SSD 6011 - Mixed use residential development within the South West Plot

Submission by:

Alan Sauran and Suzanne Aubrun

21 July 2013

## Winter Solstice (21<sup>st</sup> June)

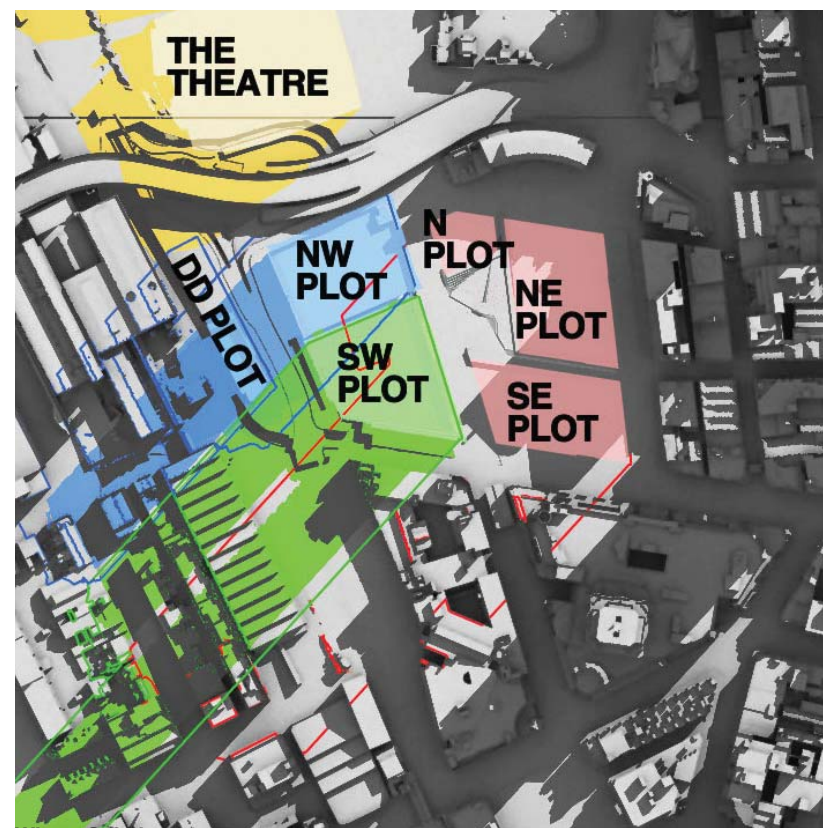
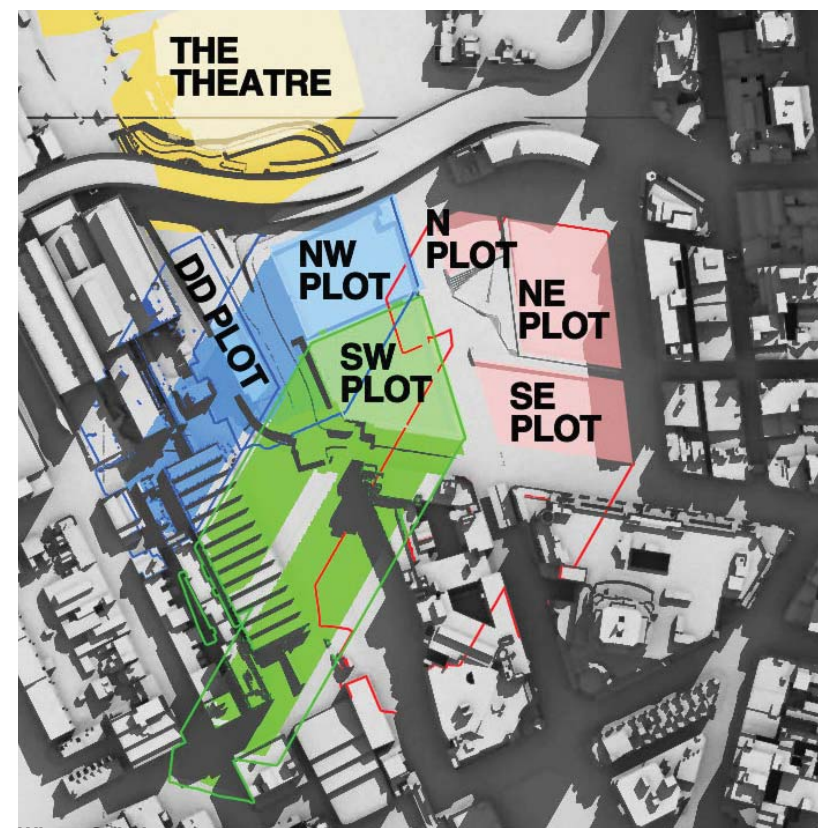
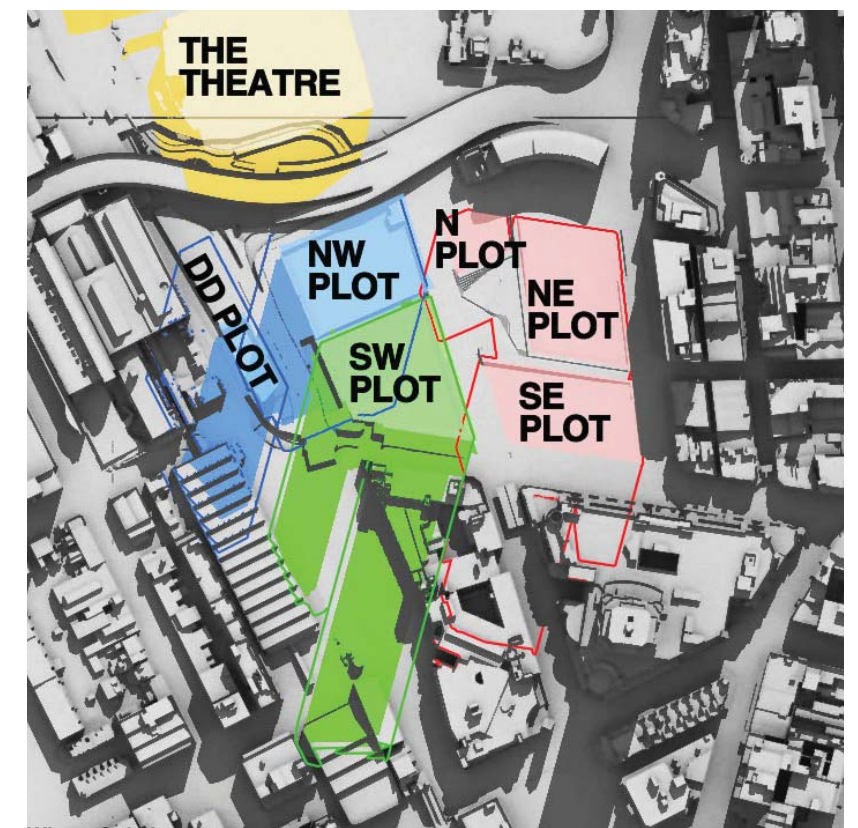
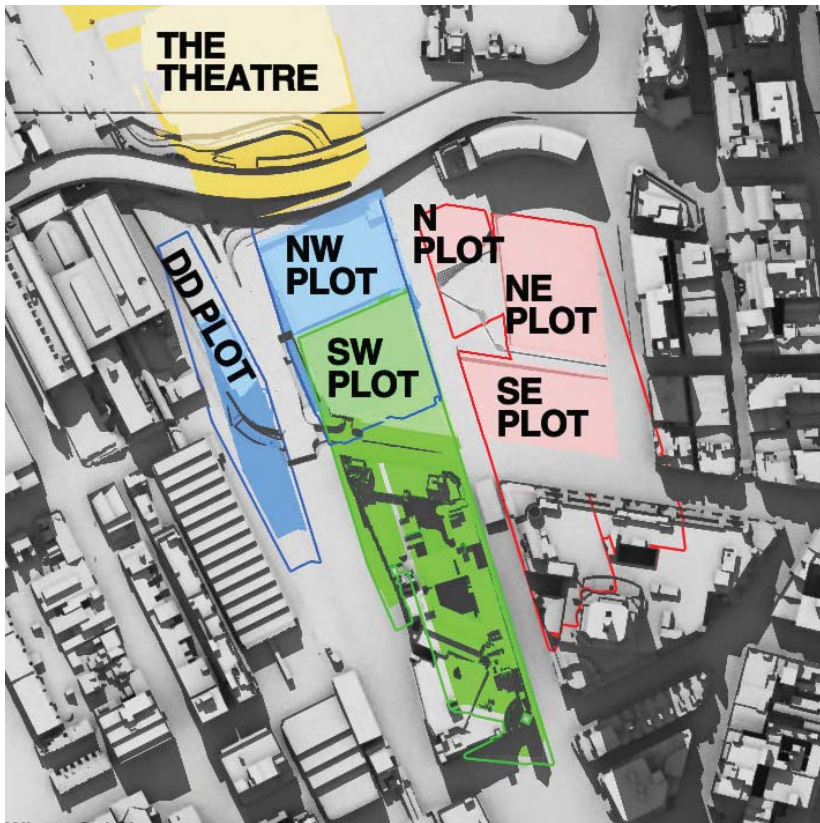
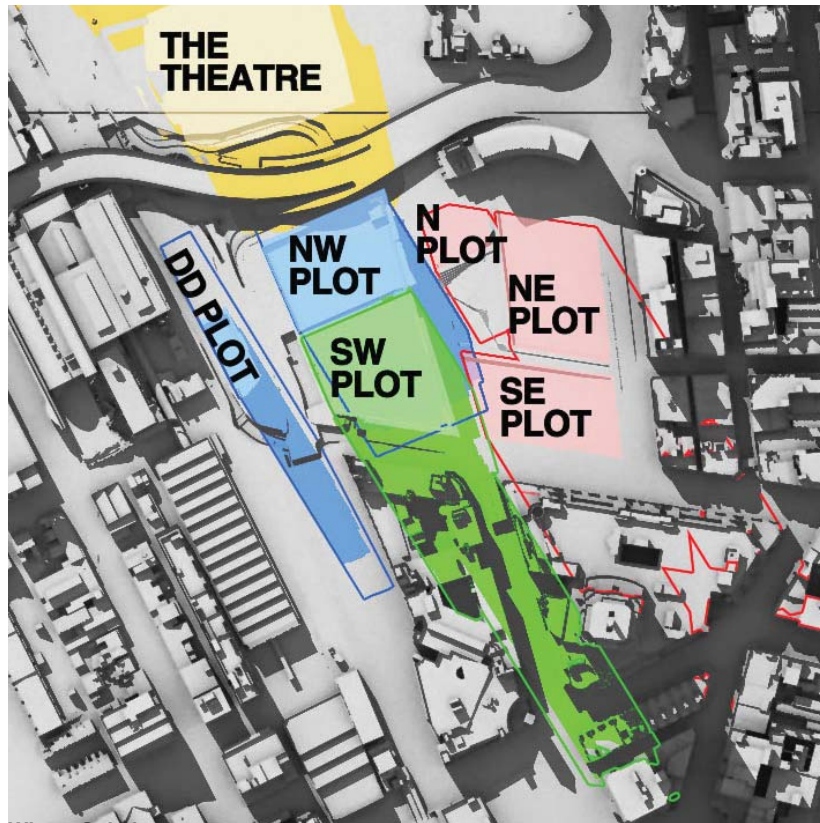
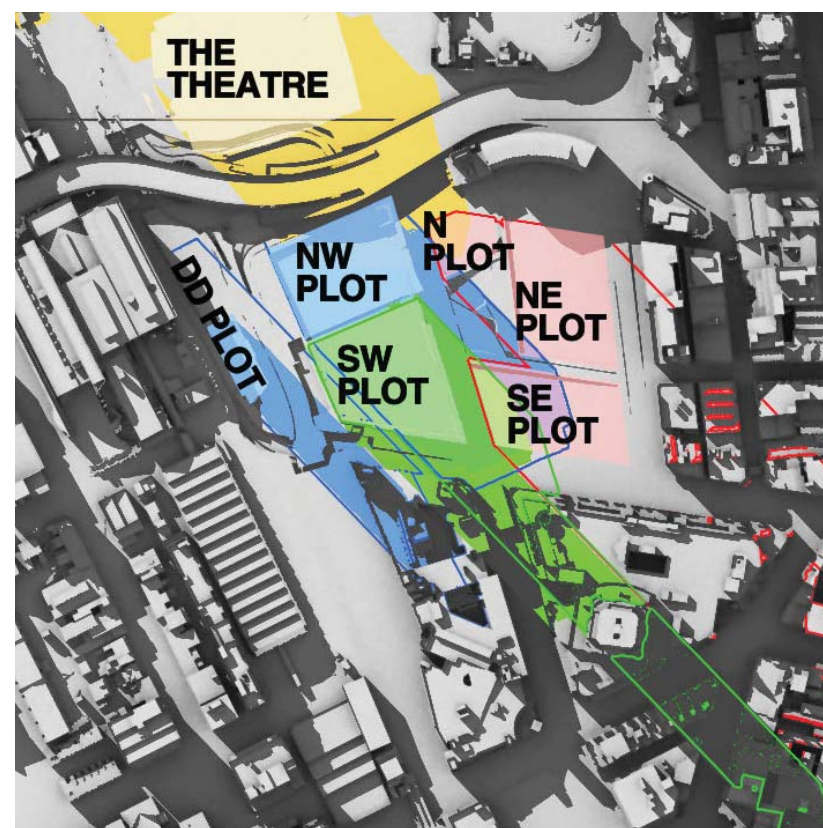
We refer to the shadow diagrams in SSD5878, Appendix H. Supplementary Design Report, Section 6. Amendments, Winter solstice - 22 June. This is not 21 June, but there would be no noticeable difference.

At 9am, 10am and 11am the west façade is totally in shadow due to other parts of The Peak building itself.

At 12pm there is still substantial existing shadowing on the west façade caused by the irregular shape of the west facade.

At 1pm the existing shadowing has been substantially removed, but not totally removed.

It can be concluded that some single aspect apartments on the west façade and some south-west dual aspect corner apartments currently receive less than 2 hours direct sunlight to habitable rooms and 50% of the private open space between 9am and 3pm on 21 June.

By 2pm the existing shadowing has been totally removed, but that is too late to achieve two hours of direct sunlight before 3pm.

At 9am, 10am and 11am the west façade is totally in shadow due to other parts of The Peak building itself.

At 12pm there is still substantial existing shadowing on the west façade caused by the irregular shape of the west facade.

At 1pm the existing shadowing has been substantially, although not entirely, removed. However, overshadowing of lower levels of the west façade by the concept proposal parameter plan shadows for the N,NE and SE plots has already started.

By 2pm the existing shadowing has been totally removed. However, overshadowing of the west façade by the SSDA4 and SSDA5 buildings has appeared and risen further up the west façade than the concept proposal parameter plan shadows for the N,NE and SE plots, which is still present.

At 3pm, the proponent states correctly that 45-45% of the western façade is overshadowed by the SSDA4 and SSDA5 buildings.

It can be concluded that, as a result of combination of the proposed development with existing shadowing of the west façade, some single aspect apartments on the west façade and the south-west dual aspect corner apartments which currently receive less than 2 hours direct sunlight to habitable rooms and 50% of the private open space between 9am and 3pm on 21 June will suffer additional overshadowing. It is beyond our skills to count the number of such apartments. We note that the proponent has made no attempt to do so.
